From: Harry Chalk
Sent: 19 January 2022 10:17
To: Planning Scanning
Subject: FW: EP/164/21/PL - Warren Recreation Ground Car Park 40 Sea Road East Preston BN16 1JP

From: East Preston Parish Council (DR) [REDACTED]
Sent: 19 January 2022 10:02
To: Harry Chalk <Harry.Chalk@arun.gov.uk>
Subject: RE: EP/164/21/PL - Warren Recreation Ground Car Park 40 Sea Road East Preston BN16 1JP

From: Lauren Willard [REDACTED]
Sent: 17 January 2022 14:35
To: Harry Chalk [REDACTED]
Cc: Dawn Reid [REDACTED]
Subject: EP/164/21/PL - Warren Recreation Ground Car Park 40 Sea Road East Preston BN16 1JP

ENV317268-LD-001

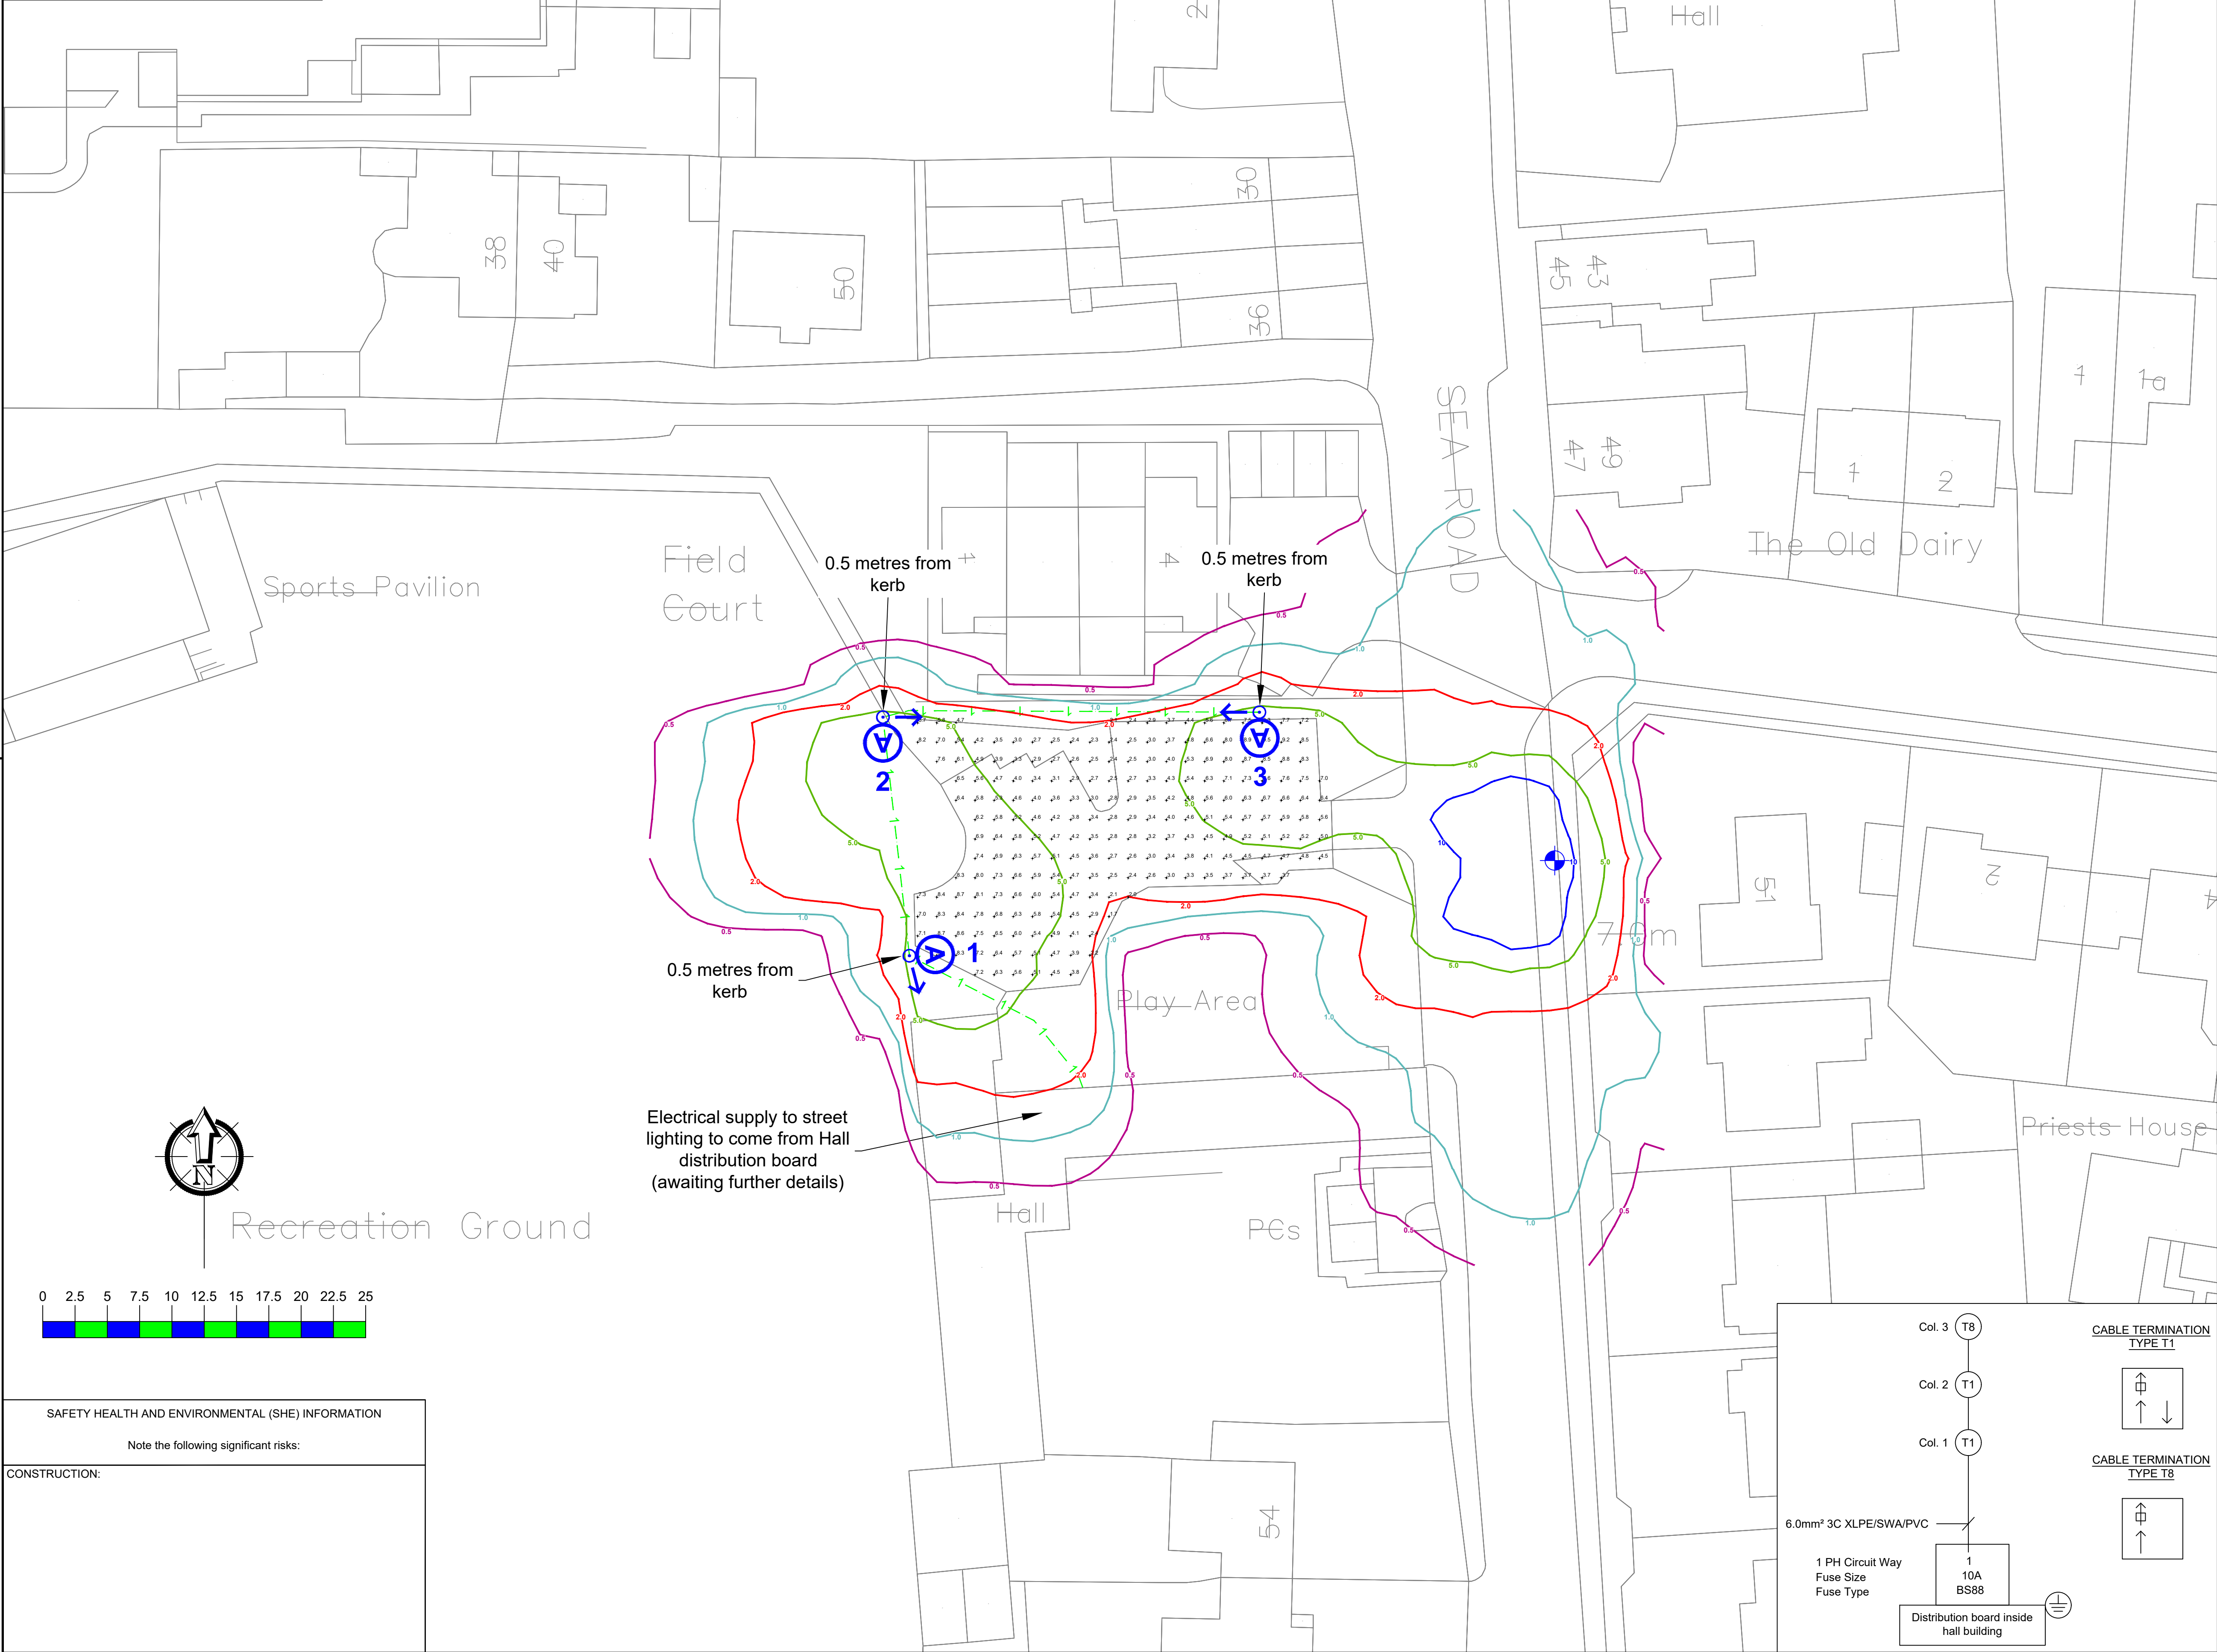
I have checked through the application documents and drawings and drawing ENV317268-LD-001 states at the top of the drawings that the columns will be made from galvanised steel and the colour will be Sherwood Green. It also states that the mounting height will be 6 metres. The application description states 5 metres. I have copied Dawn in on this email so he can confirm which is correct.

As requested, I can confirm the information stated at the top of the drawing ENV317268-LD-001, is correct.
The column height is 6 metres .
The column material is Galvanised Steel and the colour will be Sherwood Green.

I also confirm, I agree for the alterations to be made to the application description, that accurately specify the new proposed height.
